COMMUNITY DEVELOPMENT DEPARTMENT
501 Delta Avenue ♦ Marysville, WA 98270 ♦ (360) 363-8000

July 20, 2023

Re: Ideal Industrial Park – *Technical Review 1*
PA 23010

SHEET: **A1.0**

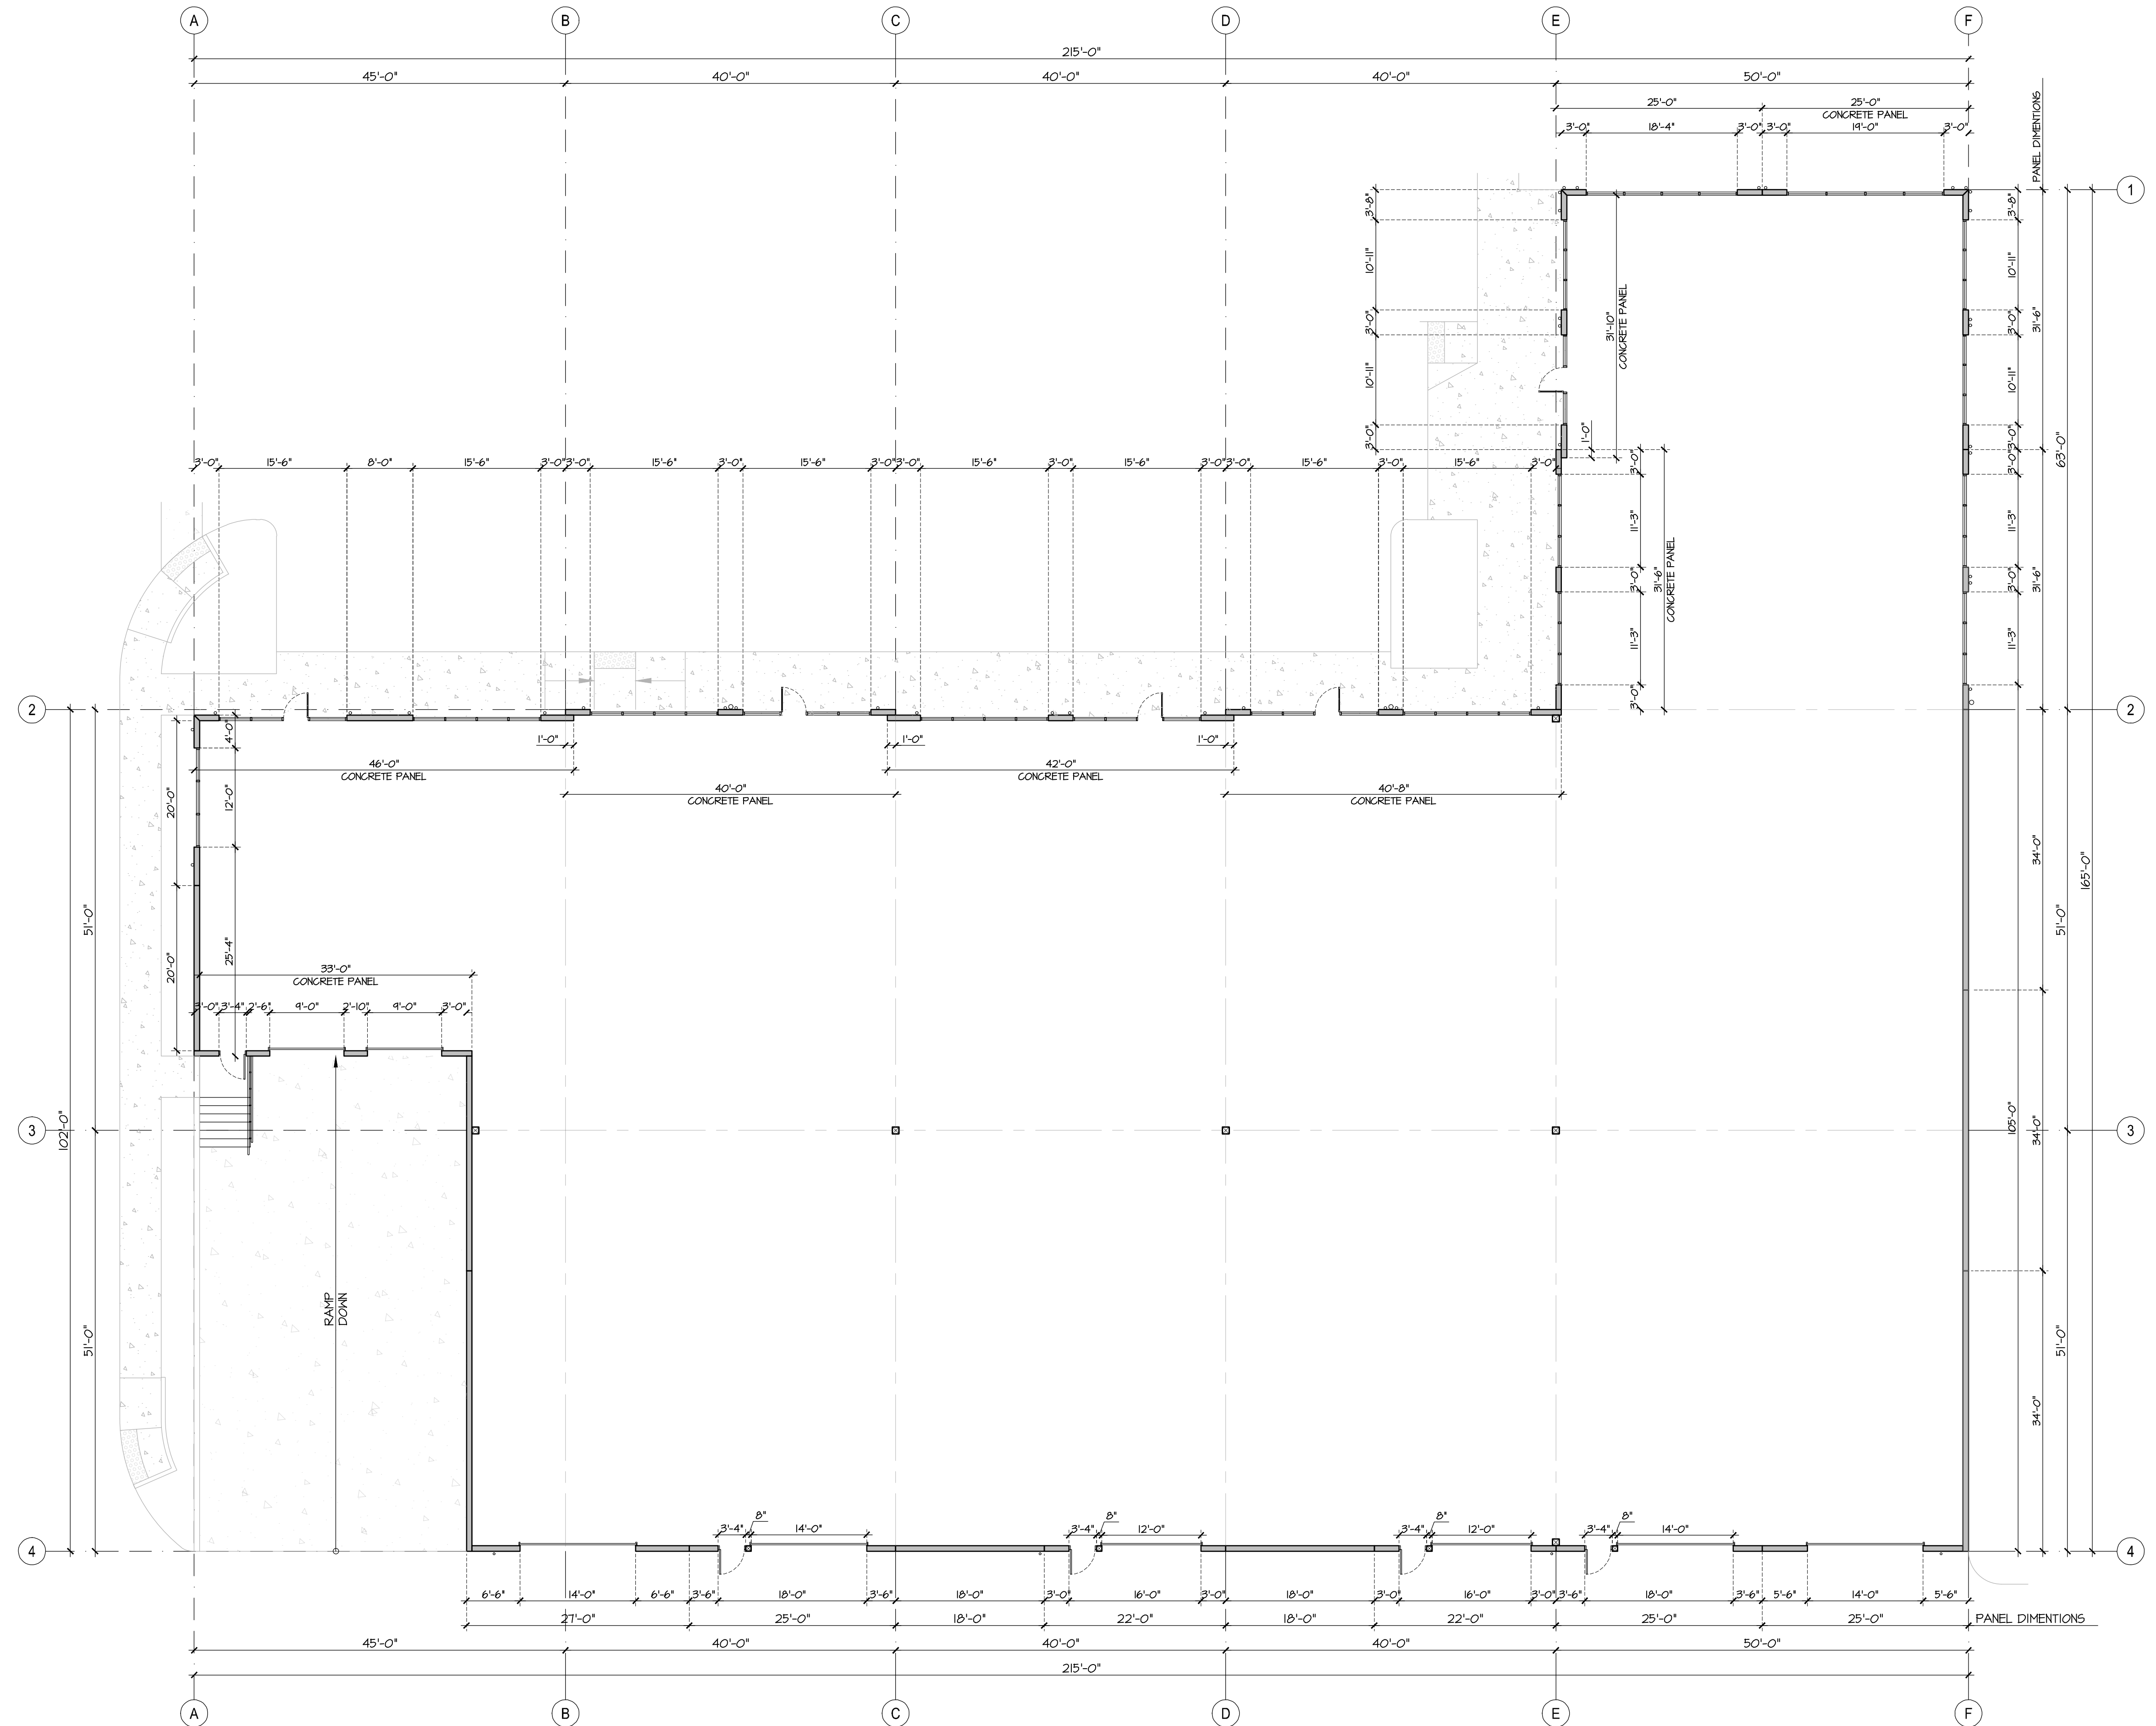
- 4. Sheet P1 shall be amended as follows:
 - a. The minimum parking stall depth shall be 18' (16' proposed). A 2' overhang is not allowed adjacent to a public sidewalk. A 2' overhang is allowed adjacent to landscaped areas.

- b. Ten (10) bicycle stalls shall be provided (4 proposed).
 - c. The proposed pedestrian pathways traversing the parking areas shall be constructed with decorative concrete and not striped.

- d. Amend Note to read: "Per MMC ~~22C~~.020.340(2) any mechanical. . ."
 - e. Amend Notes to include all of the following:
 - . Where illuminated signs and illuminated areas are permitted, such illuminating devices shall be shaded and/or directed so as not to visibly create a nuisance to any property in a residential zone classification. Residential zoning is located to the east of the proposed development.
